Your Ref: BR/67/25/PL

Our Ref: LM/ARU/25/06A

Date 7th May 2025

RE: 57 Queensway Bognor Regis PO21 1QN

Drawing  
**BIKE STORE**

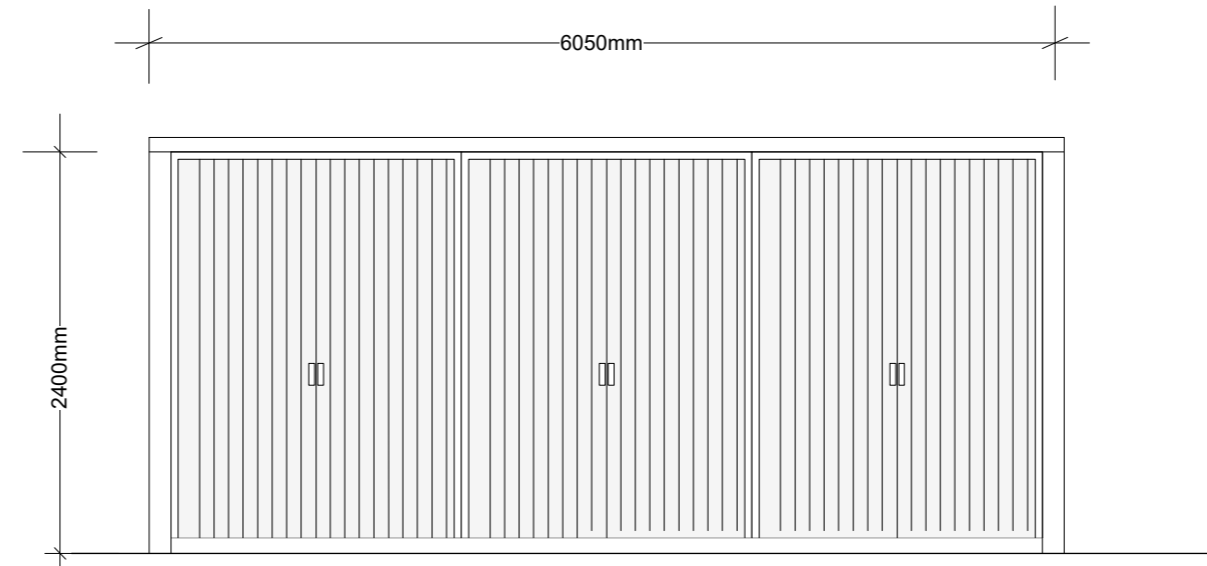
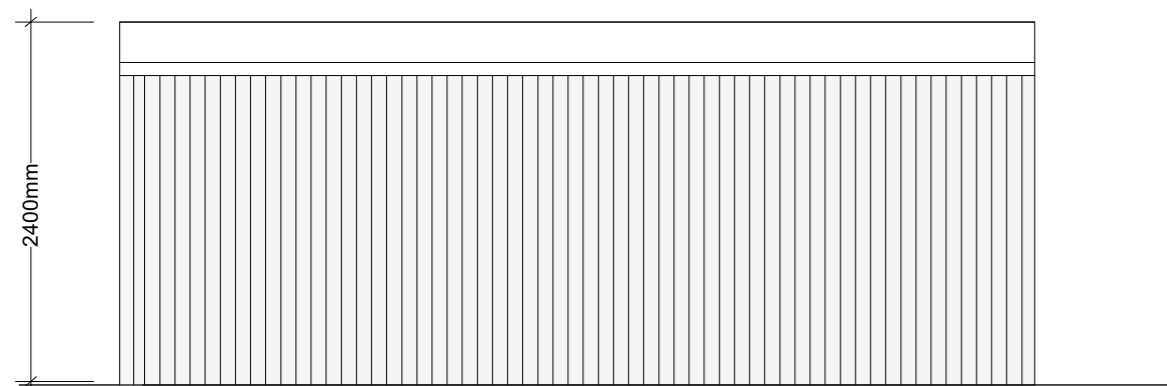
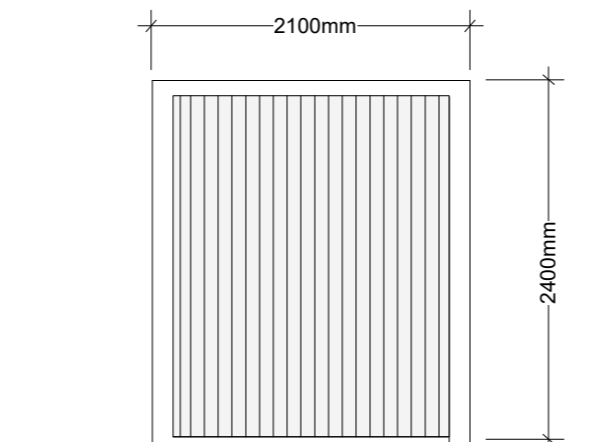
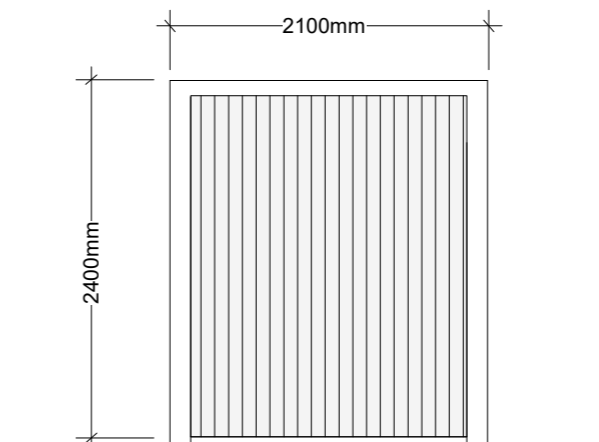
With regards to proposed cycle parking within the development - research by the 'Design against Crime Centre' suggests that cyclists should be encouraged to lock both wheels and the crossbar to a stand rather than just the crossbar and therefore a design of cycle stand that enables this method of locking to be used is recommended. The minimum requirements for such equipment are as follows: • Galvanised steel bar construction (minimum thickness 3mm), filled with concrete; • Minimum foundation depth of 300mm with welded 'anchor bar'.

It is also the developer or developer's agent's responsibility to inform the Responsible Person(s), Fire and Rescue Service and Building Control of any bicycle storage facilities and/or other areas that may require the charging and storage of Lithium-ion powered vehicles or devices, within buildings or the wider site footprint, to ensure that the necessary fire suppression measures for the charging and storage of lithium-ion powered vehicles have been considered and specified.
